Response to the Applicant's Noise Assessment Update

Note by William David Moore

The applicant has submitted a document titled [Written Statement of Oral Case ISH3 \[Appendix F - Noise Assessment Update Note\]](#). In a roundabout way, the applicant's document attempts to justify the absence of attenuation corrections to the sound of train pass bys measured by NMP4.

NMP4 - Time History Graph

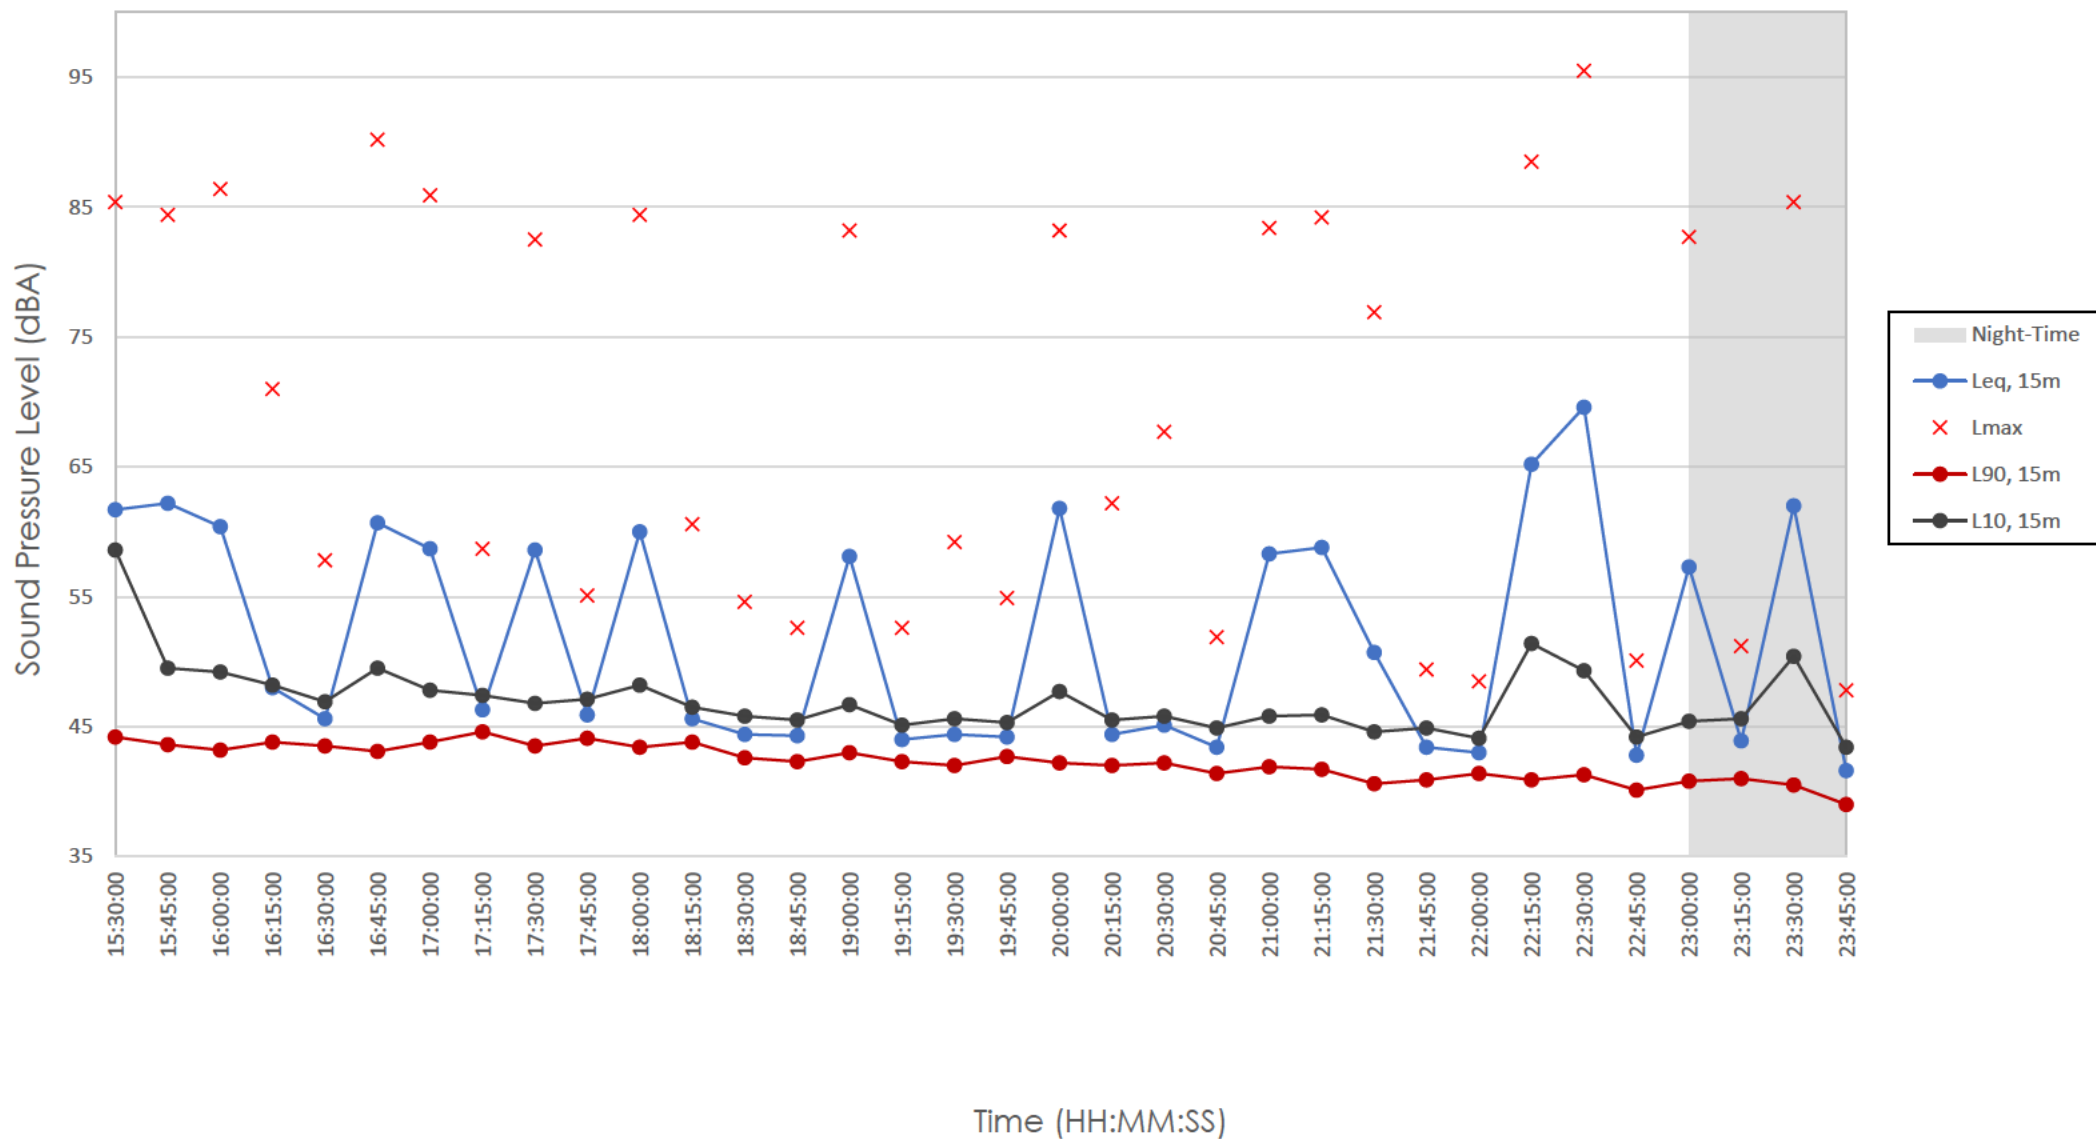
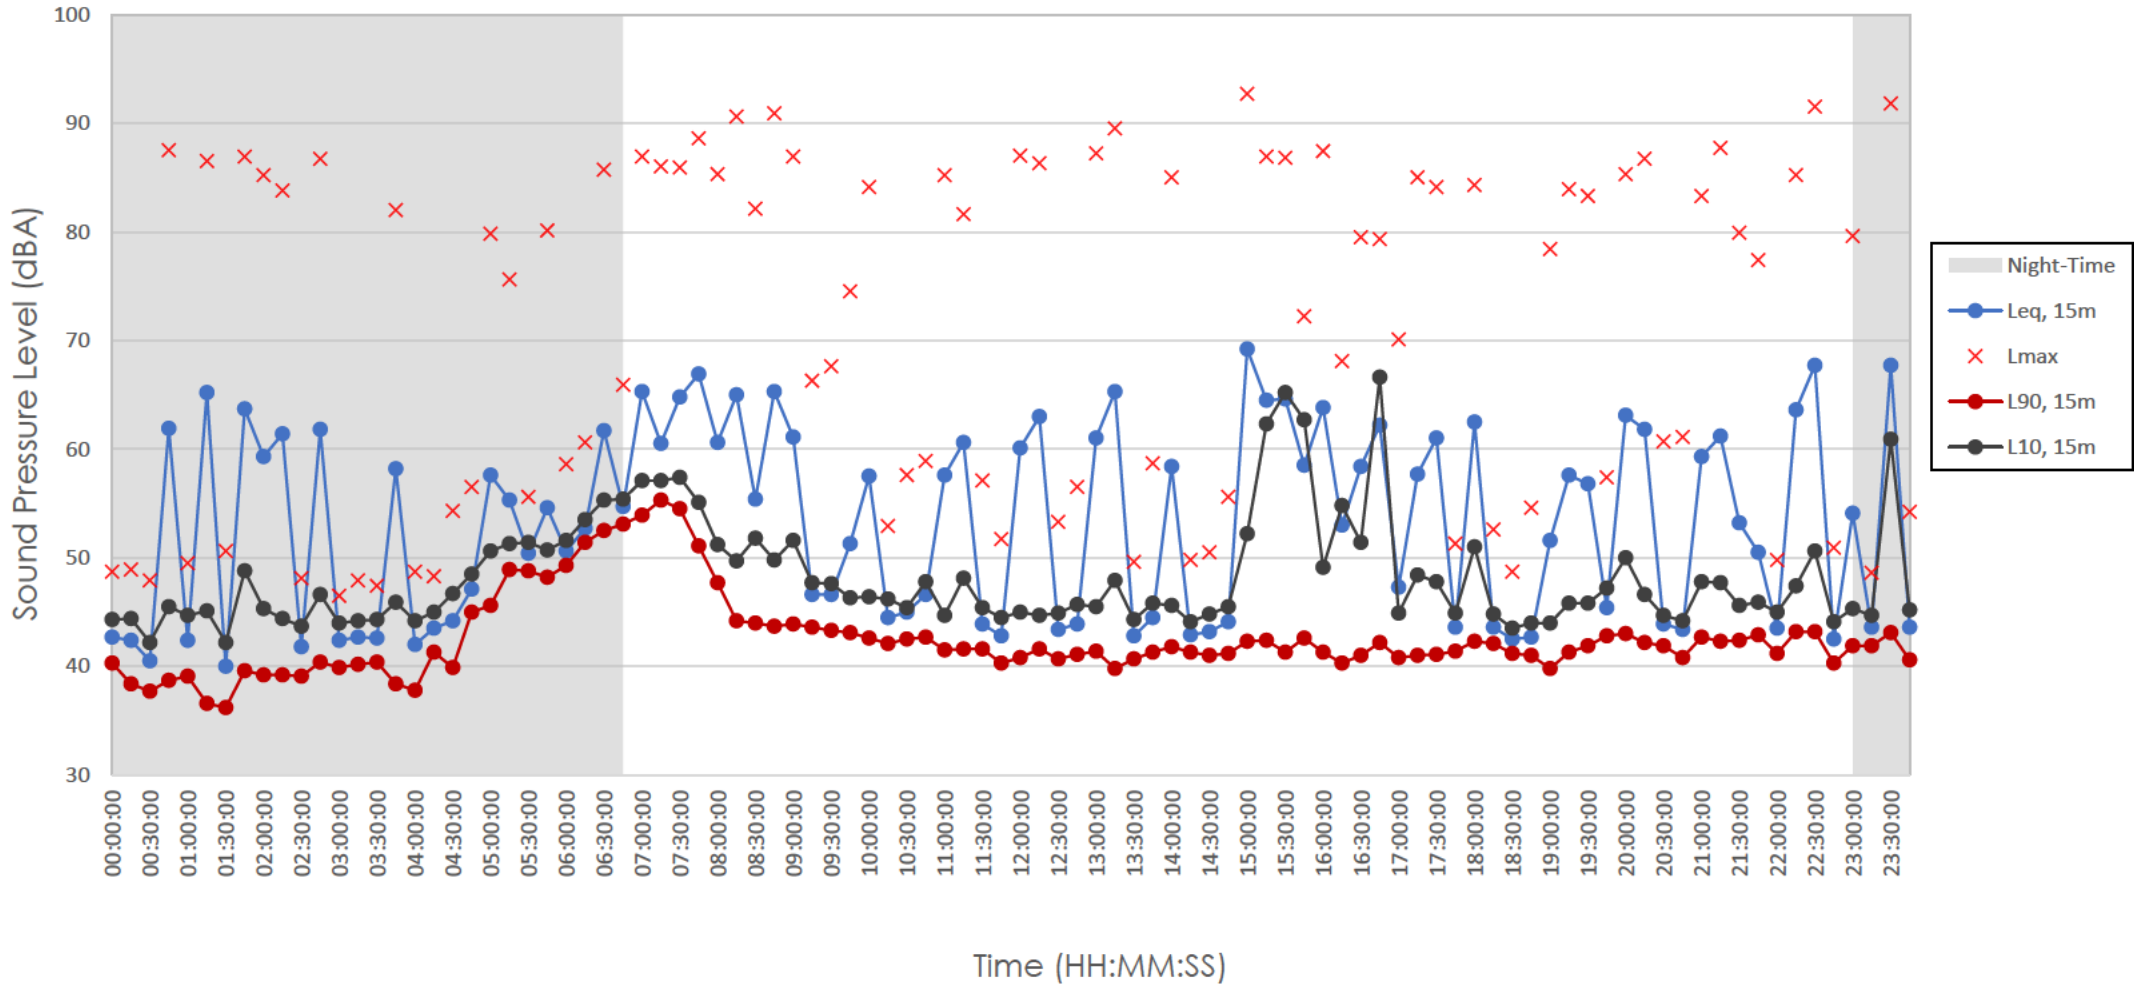
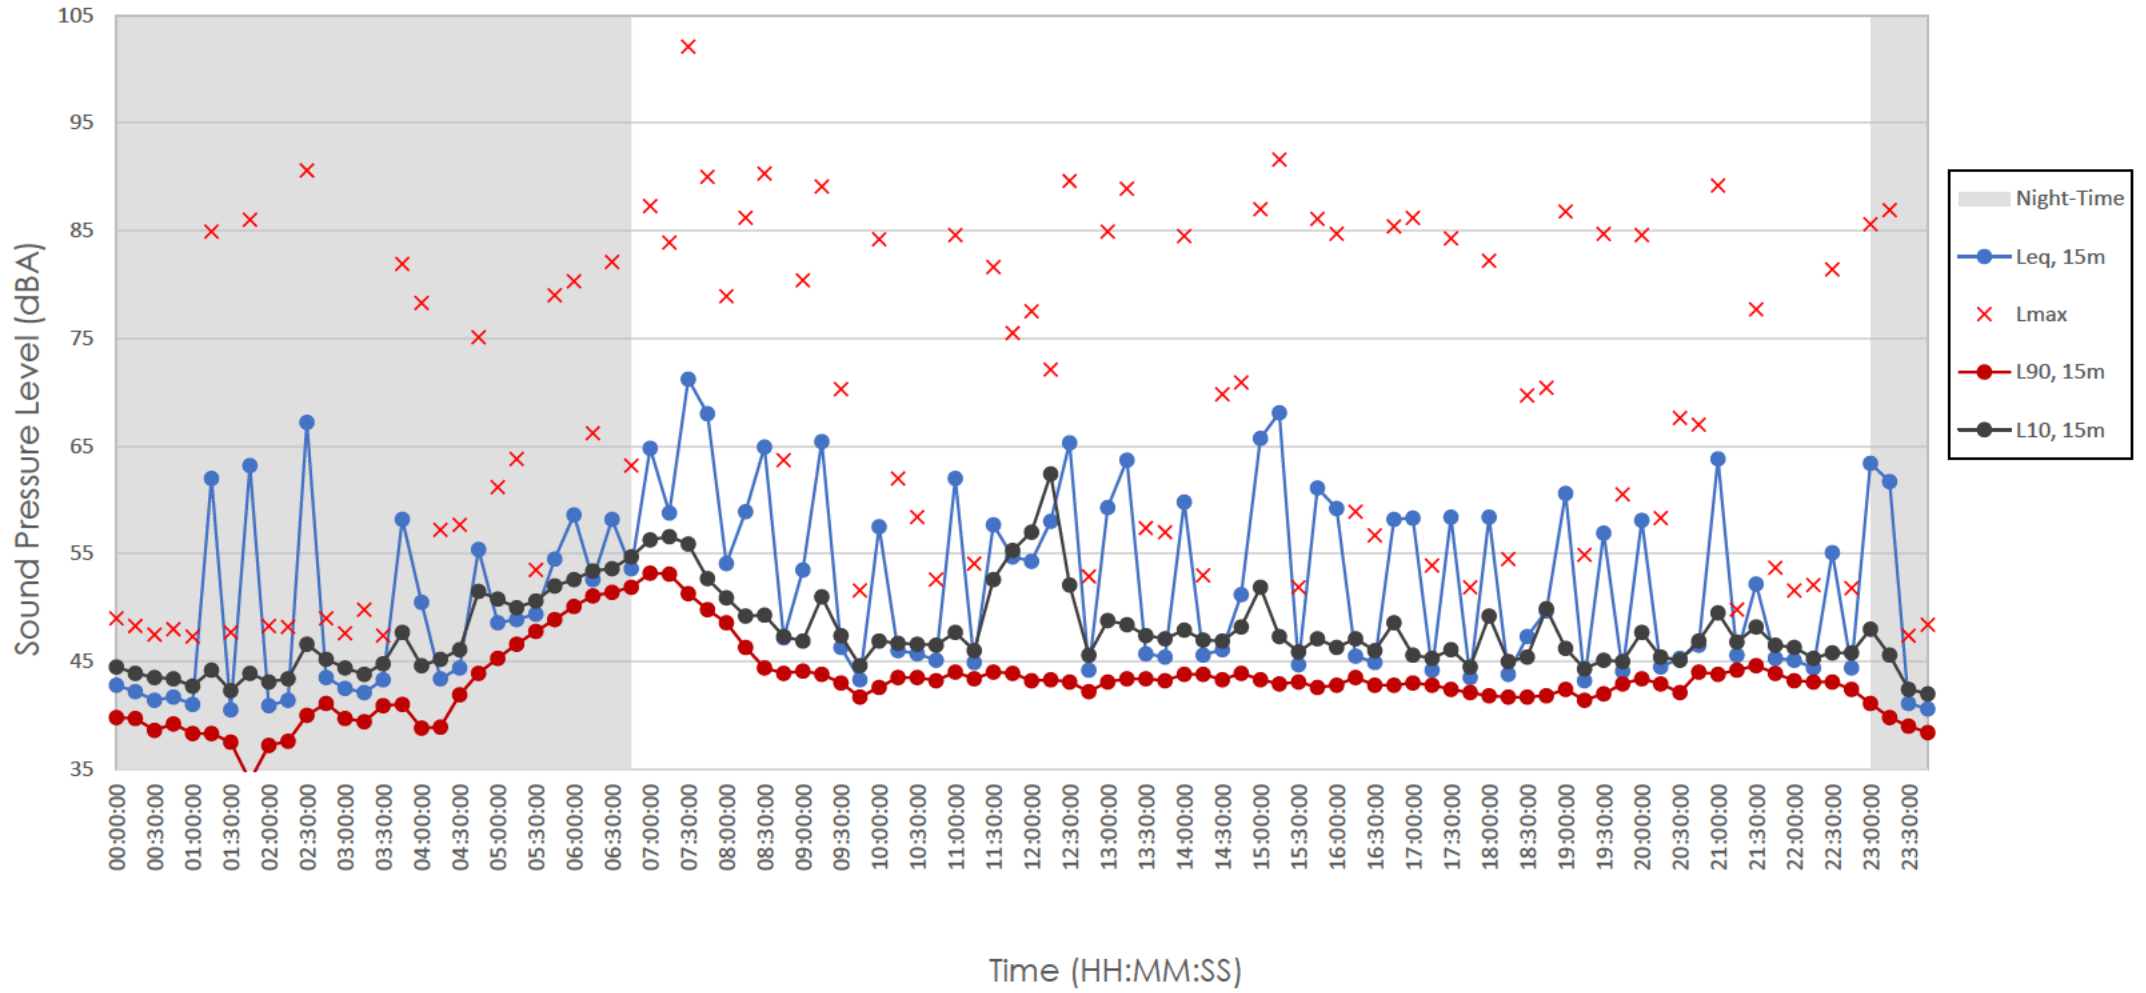
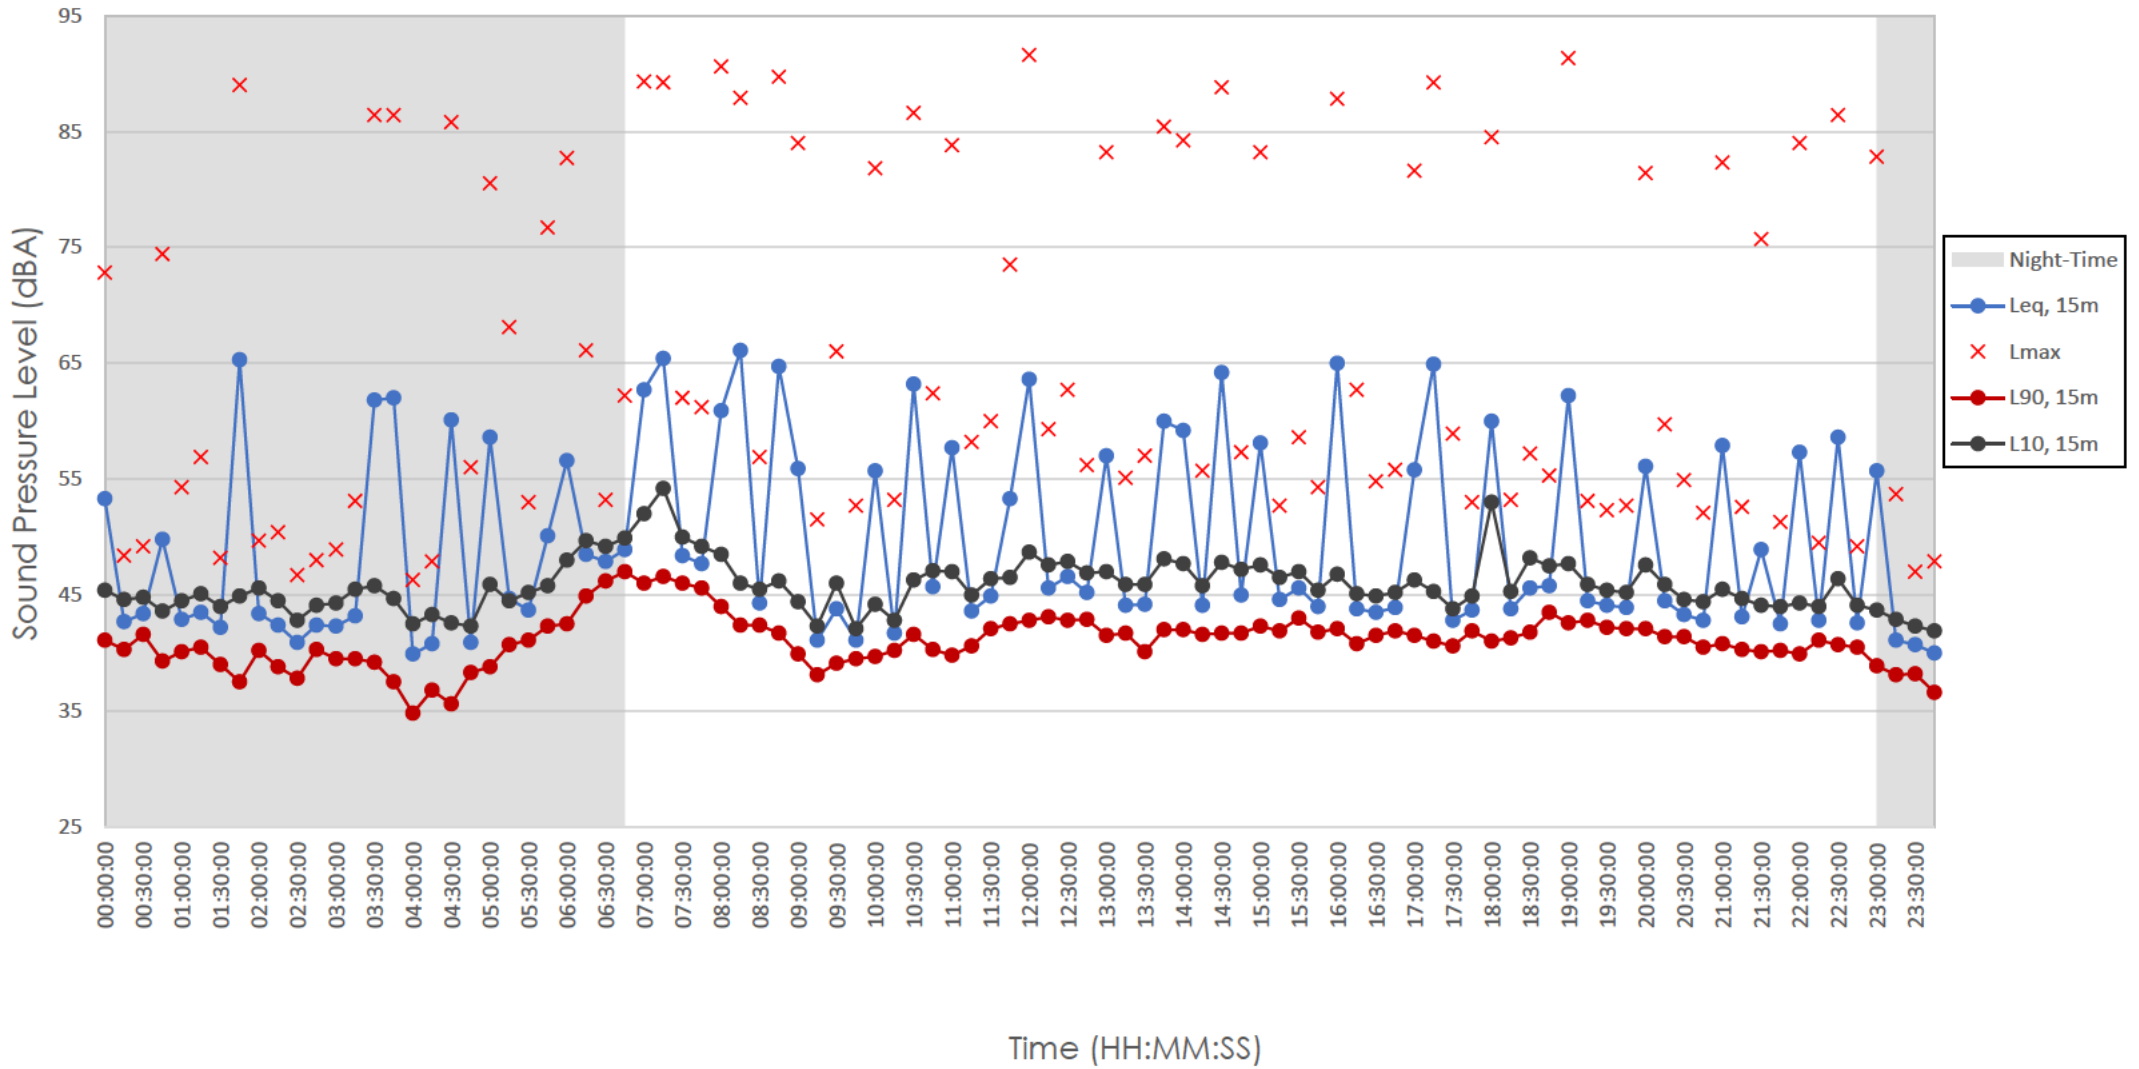
The ambient sound levels measured by NMP4 are utterly dominated by sound of extremely close proximity train pass bys with far lower sound levels when trains aren't passing by, i.e. almost all the time. Overwhelming evidence of this is contained within the summary results pages for NMP4, as explained below in points 1-4. An example summary results page is included in Figure 1, below.

1. The LAeq sound levels repeatedly spike up and down throughout the daytime and night-time by ~15-20 dB from the low-mid forties, up to 55-65 dB. These spikes are caused by the sound of extremely close proximity train pass bys. Distant road noise would not cause these repeated spikes.

2. If these high LAeq sound levels were caused by the distant road noise we would always see the LA10 levels spiking along with the LAeq levels, but we don't because they're caused by train pass bys and train pass bys are inherently brief.

3. If these spikes were caused by changes in the distant road noise, we would see significant changes up and down in LA90 levels, but we don't because they're caused by train pass bys and train pass bys are inherently brief. This is why there's a gap of 20 dB between the weekday daytime background sound level in the report and the weekday daytime ambient sound level in the report. The train pass bys have no impact on the measured background sound levels, which contain the distant road noise. This is why NMP4's measured background sound levels can simply be copied to NSRs 1-8 & 24-26.

4. The spread between the LA90 levels, LAeq levels, and LA10 levels is very tight in those 15 minute periods which don't contain spikes in LAeq levels. This is because these time periods are dominated by the distant road noise in the low-mid forties dB. The gap between the LA90 levels and the LA10 levels remains stable during periods with spikes in LAeq levels because the distant road noise is stable.

We end up with weekday daytime ambient sound levels used in the report for NMP4 of almost 60 dB, which are then applied to NSRs 1-8 & 24-26. This isn't because of distant road noise, it's because of the sound of extremely close proximity train pass bys.

The applicant needs to be returned to the measured sound levels at NMP4 and the applicant needs to apply attenuation corrections to the measured sound of train pass bys to generate ambient sound levels at NSRs 1-8 & 24-26 during weekday daytimes, weekday night-times, weekend daytimes and weekend night-times.
